REQUEST	Current Zoning: O-2, office Proposed Zoning: B-2 (CD), business general conditional
LOCATION	Approximately 1.13 acres located on the southwest corner of Beatties Ford Road and Fairdale Drive.
CENTER, CORRIDOR OR WEDGE	Corridor
SUMMARY OF PETITION	This petition proposes to rezone the property to B-2(CD) to allow the development of a Women's Transition Center for up to thirty women.
STAFF RECOMMENDATION	Staff recommends approval of this petition upon resolution of outstanding issues. The petition is consistent with the <i>Northwest District Plan</i> .
Property Owner	Friendship Missionary Baptist Church
Petitioner	Friendship Missionary Baptist Church
Agent/Representative	Jennifer Coble
Community Meeting	Meeting is required and has not been held.

PLANNING STAFF REVIEW

Planner: Solomon Fortune (704) 336-8326

04DEC08	NEW SURVEY
17NOV08	ZONING COMMENTS
PROJECT	0812
DATE	21APR08
DRAWN BY	PML
CHECKED BY	CEL
SITE PLAN	
A1

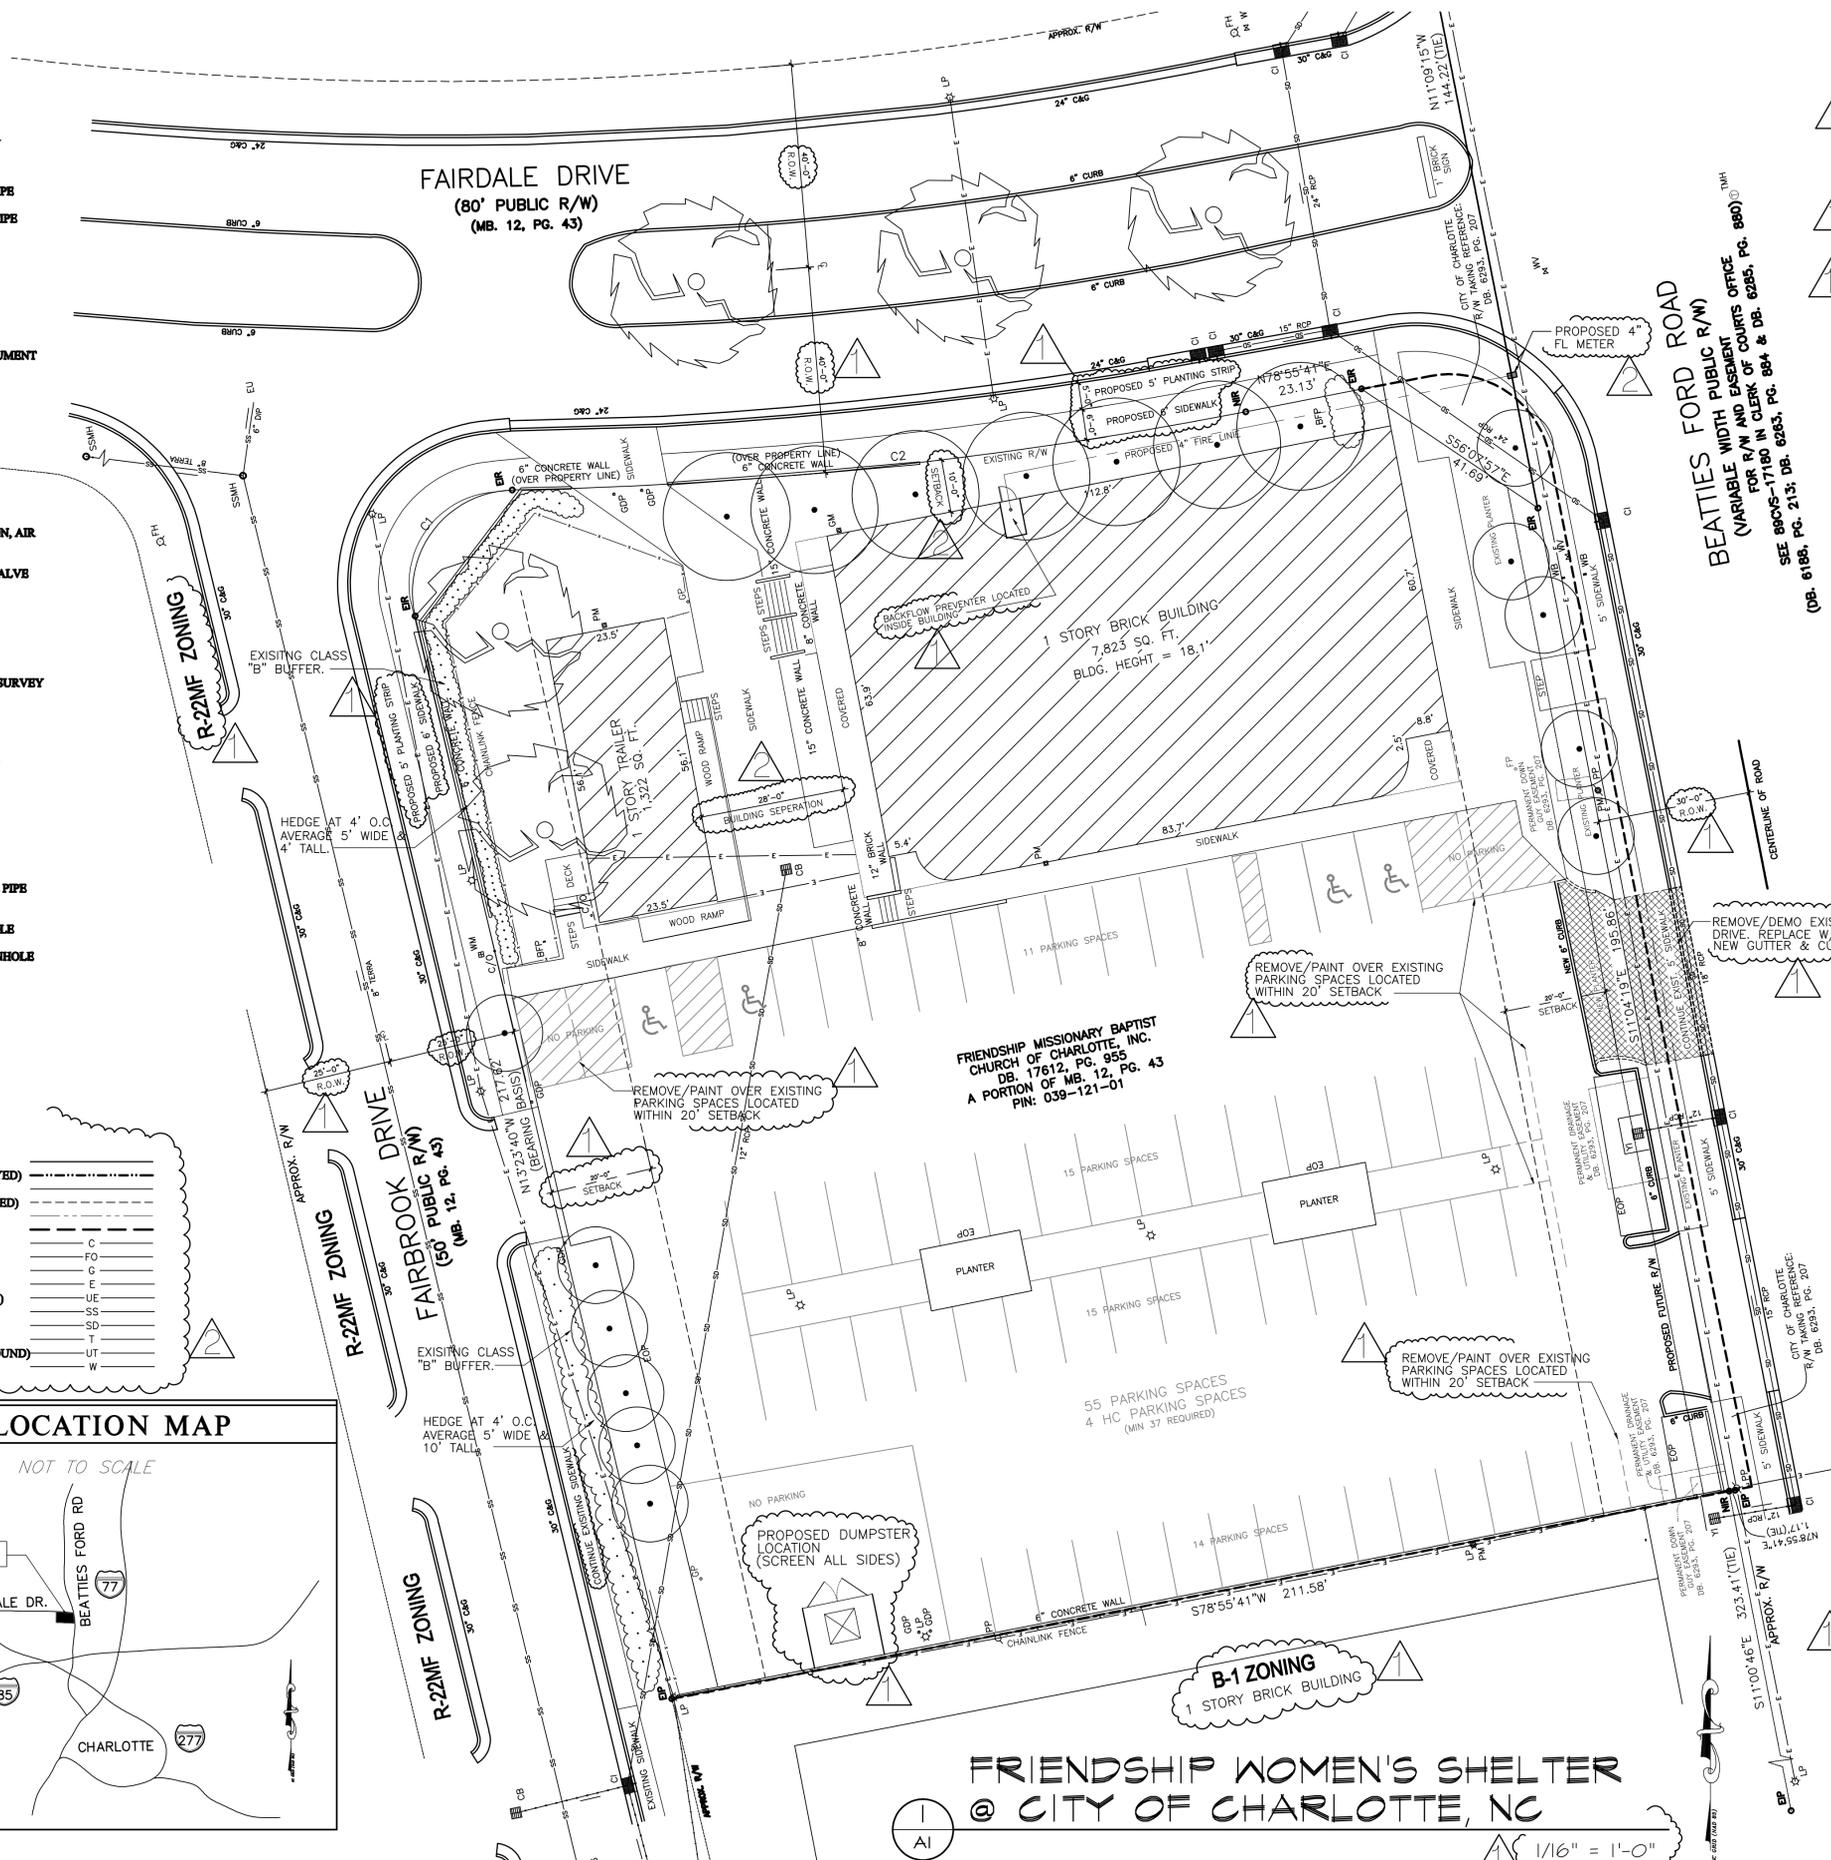
CDOT: Requests that the drive aisle be removed so that no maneuvering is allowed in the setback.

1. Remove the drive aisle to prevent maneuvering in the setback.
 2. Add trees and or landscaping to the center median in the parking lot.
 3. Label width of sidewalk and planting strip along Beatties Ford Road.
 4. Amend the General Note to confirm that there is no other homeless shelter, nor group home, within 800 feet of the site.
 5. Amend Note 4 under General Provisions to allow up to 30 women to be housed overnight.
 6. Amend Note 1 under Access Points to specify only one access off Beatties Ford Road.
 7. Add note that parking will be screened from abutting properties and from view from public streets.
-
